WELWYN HATFIELD COUNCIL – DEVELOPMENT CONTROL
DELEGATED REPORT

APPLICATION No:	N6/2011/2643/AD
------------------------	------------------------

This application seeks advertisement consent for the erection of an illuminated totem sign. This would have a height of 4.5m and would advertise the Beefeater restaurant at the site.

STANBOROUGH - TOTEM SIGN ELEVATION & SECTION 1:50 AT A4

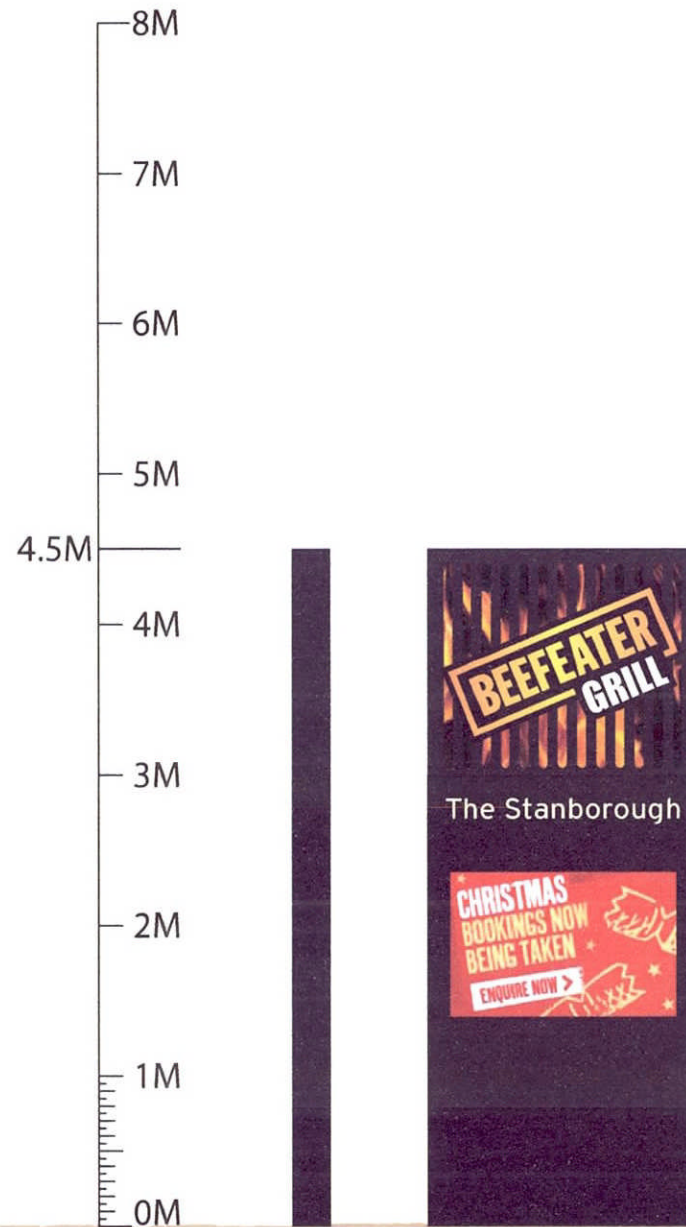
The proposed sign, which would have a height of 4.5m, is located with two other signs, all of which are prominent in Stanborough Road and relatively large and appear to have been located at the site in a haphazard uncoordinated manner. It is considered that a further totem sign at this site which is approximately the same height as the existing Premier Inn totem sign and which would be illuminated would further add to the visual clutter of this section of Stanborough Road. Whilst the signage itself would not be that unreasonable along such a main road on its own, it is considered that the amount of signage that would result at the site, two of which would be illuminated totem signs adjacent to each other, would have the greatest impact on the street scene. Therefore the introduction of a further totem sign, of the height and illumination proposed, is considered would be unduly prominent when travelling along this road, creating visual clutter to the detriment of the character of the street scene. The restaurant is within a prominent position along Stanborough Road where customers have a clear view of the building. It is considered that whilst appreciated that a company needs to advertise its presence, a further totem sign at the site does not justify the harm to the visual amenity which results from the existing signs or their continued display.

In addition, the sign is illuminated and whilst the level of luminance is 300cd/m² which complies with the recommendations in the Institution of Lighting Engineers, this would further emphasise its presence within the street scene of Stanborough Road.

Subsequently it is considered that a further totem sign, so close to an existing totem sign, is unsuited to the local context and detract from the visual amenities of the locality.

The proposed sign, by virtue of its siting, scale and illumination together with the existing signs at the site would create a cluttered appearance of this part of the street scene of Stanborough Road which would not comply with the design criteria in the Supplementary Design Guidance. The proposed development would therefore be contrary to PPG19 and Policies GBSP2, D1 & D2 of the Welwyn Hatfield District Plan and Supplementary Design Guidance; Statement of Council Policy 2005

1. By virtue of the number of signs already at the site together with the siting, scale and illumination of the proposed totem sign, would result in a more cluttered appearance of the street scene of Stanborough Road that would be detrimental to the character and visual amenity of the surrounds. This would fail to be compatible with the maintenance or enhancement of the character and appearance of the area as stated in policy GBSP2 of the Welwyn Hatfield District Plan, 2005. The proposed development would therefore be contrary to PPG19 and Policies GBSP2, D1 & D2 of the Welwyn Hatfield District Plan and Part 6 of the Welwyn Hatfield District Plan, Supplementary Design Guidance, Statement of Council Policy, 2005.
